APPROVED
Limited building only review
Permit holder responsible for full compliance with the code

Harnett COUNTY
NORTH CAROLINA

04/24/2023

BUILDER	Weaver Development Co. Inc.	CITY / CO.	Johnston Co. / Johnston
JOB NAME	Blackwell Pole Barn	ADDRESS	Site Address
PLAN	Custom	MODEL	Floor
SEAL DATE	Seal Date	DATE REV.	04/21/23
QUOTE #	Quote #	DRAWN BY	David Landry
JOB #	J0423-1870	SALES REP.	Lenny Norris

1 Truss Placement Plan

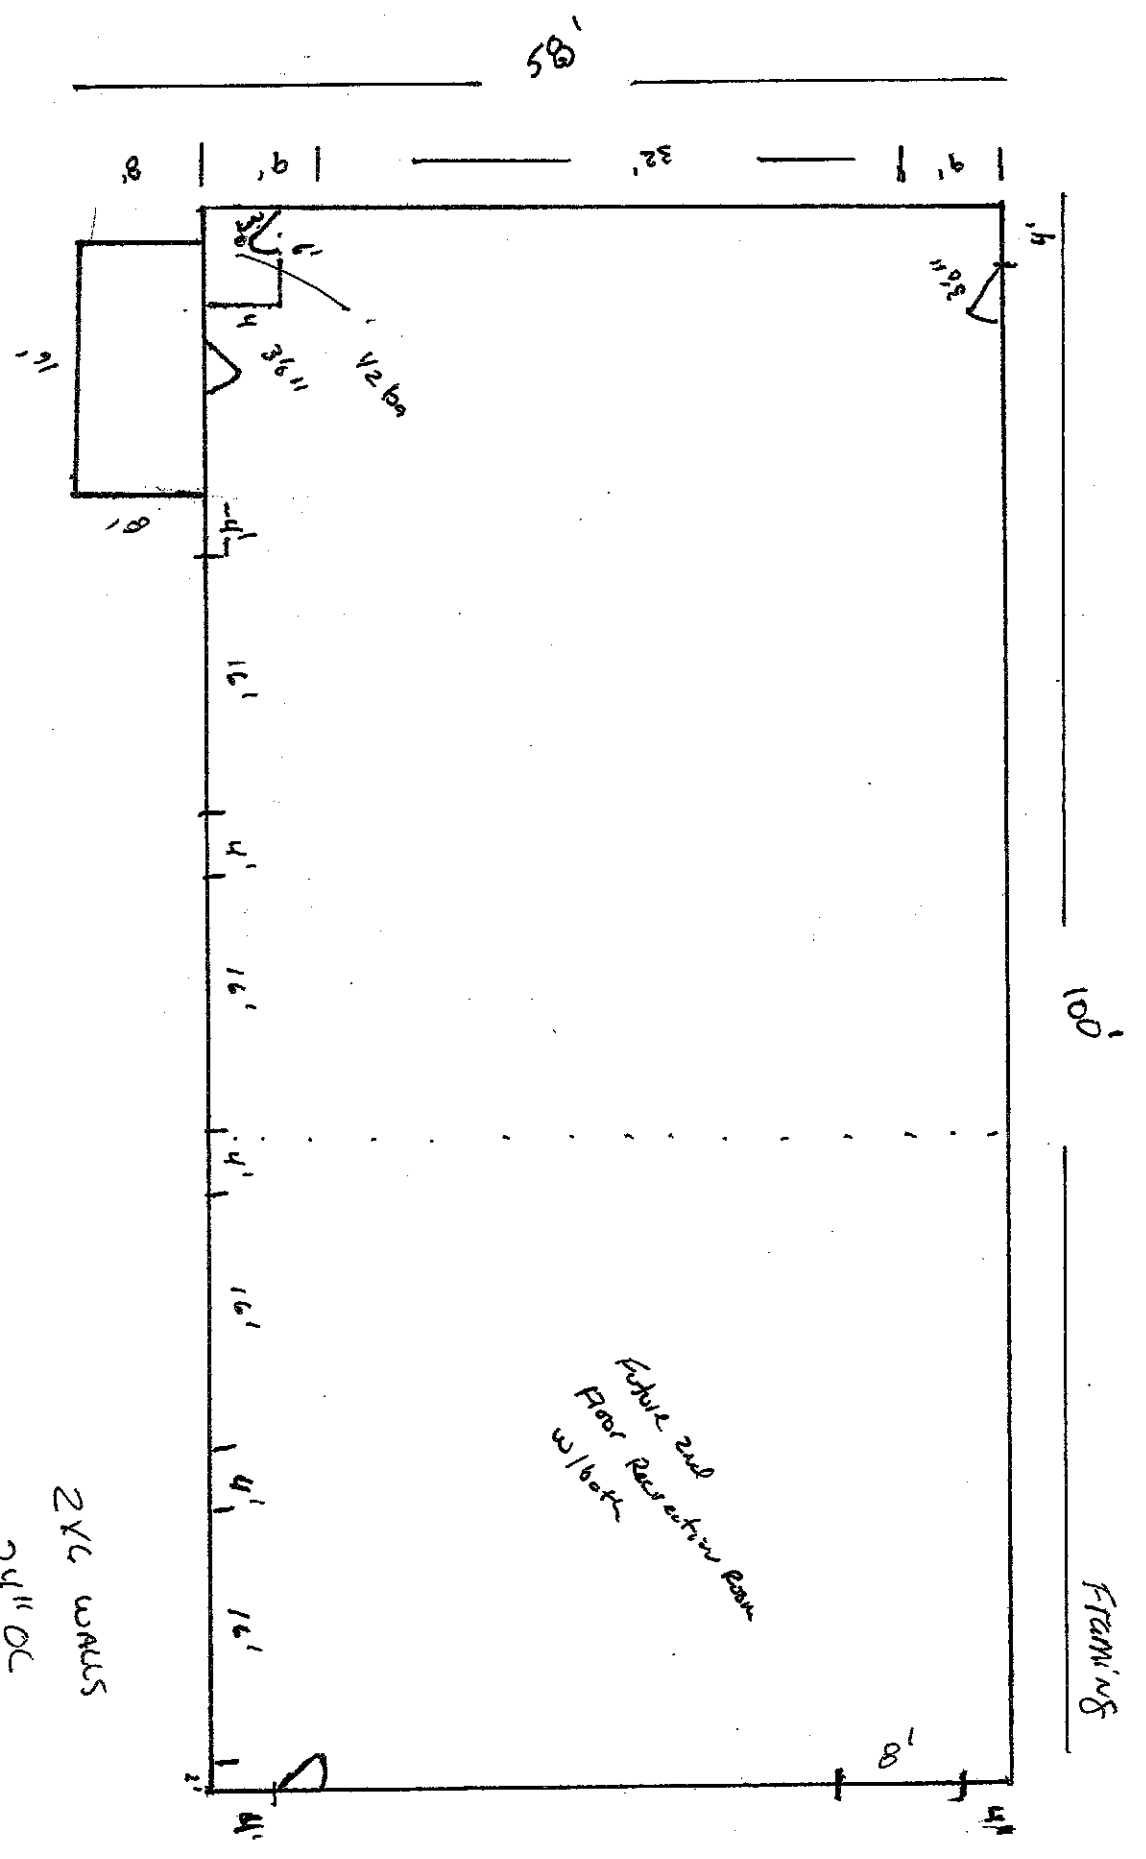
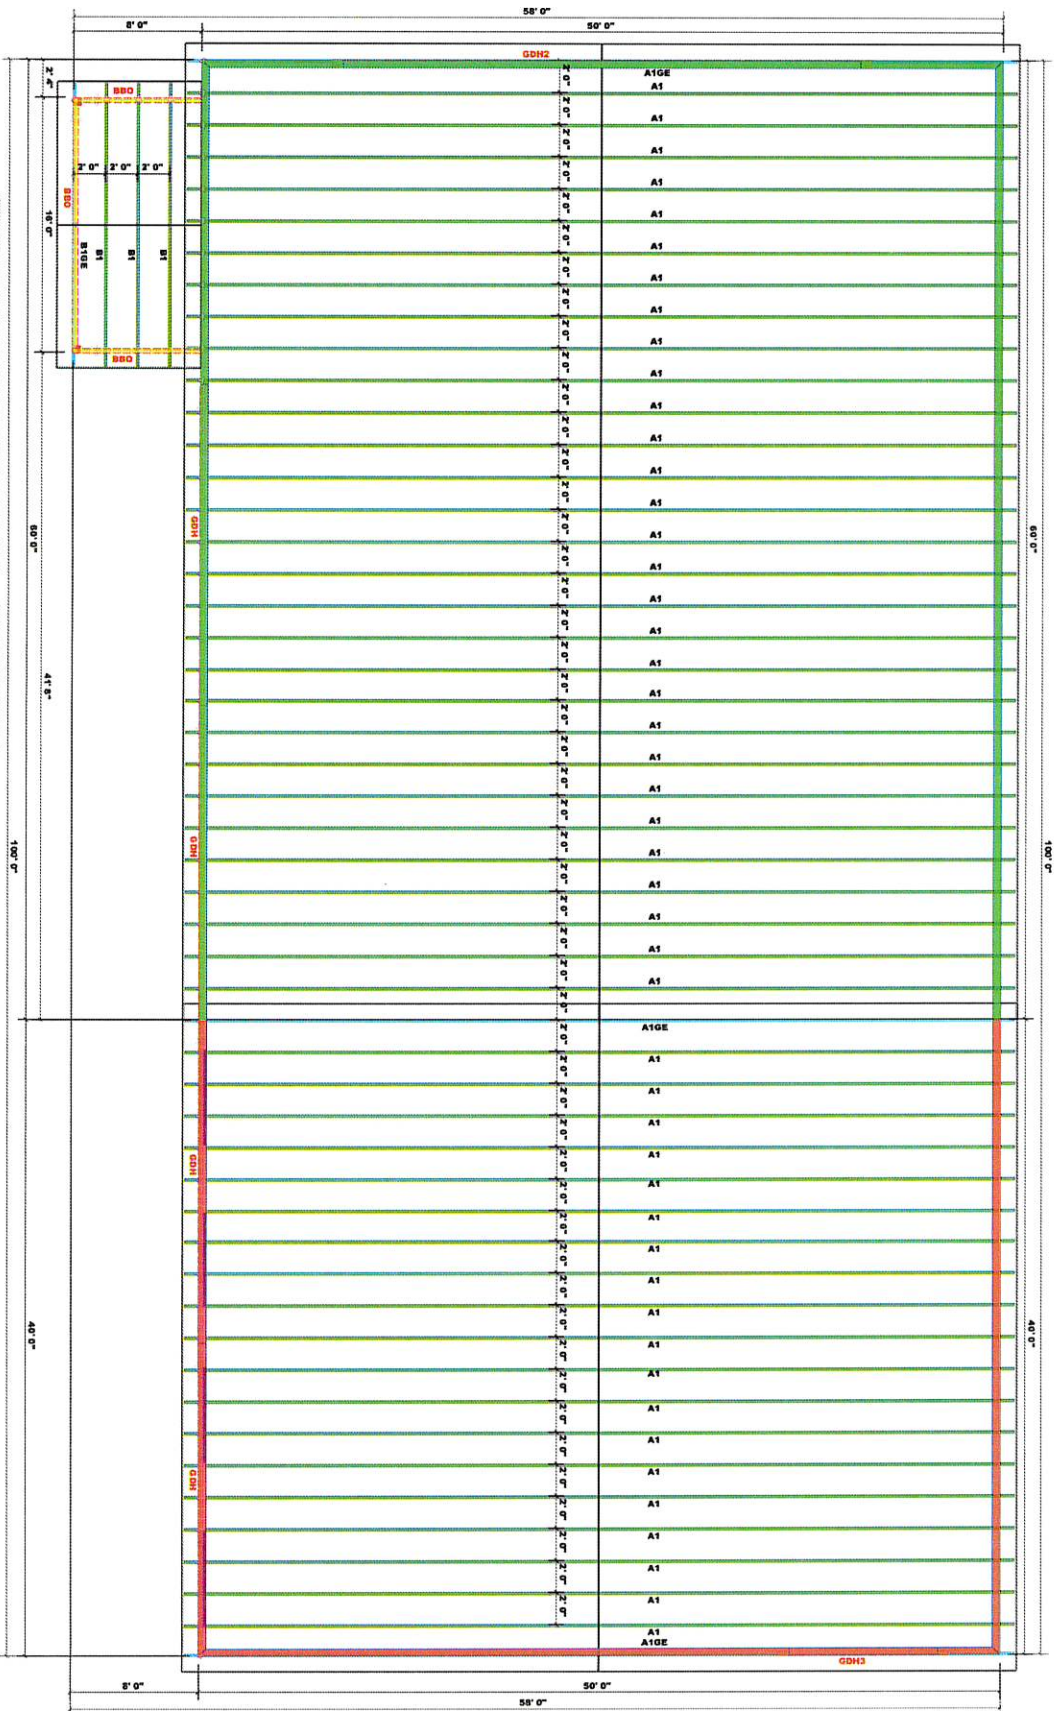
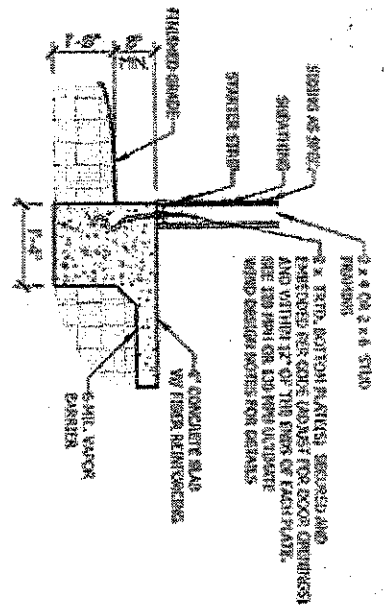
**SEE NOTES THROUGHOUT.
MAX STUD HEIGHT IS 10 feet
IF STUD HEIGHT EXCEEDS 10
FT. THEY MUST BE 2X6, 16 OC
WITH BRIDGING NO MORE THAN
4 FEET APART TO A MAX
HEIGHT OF 16 FT.**
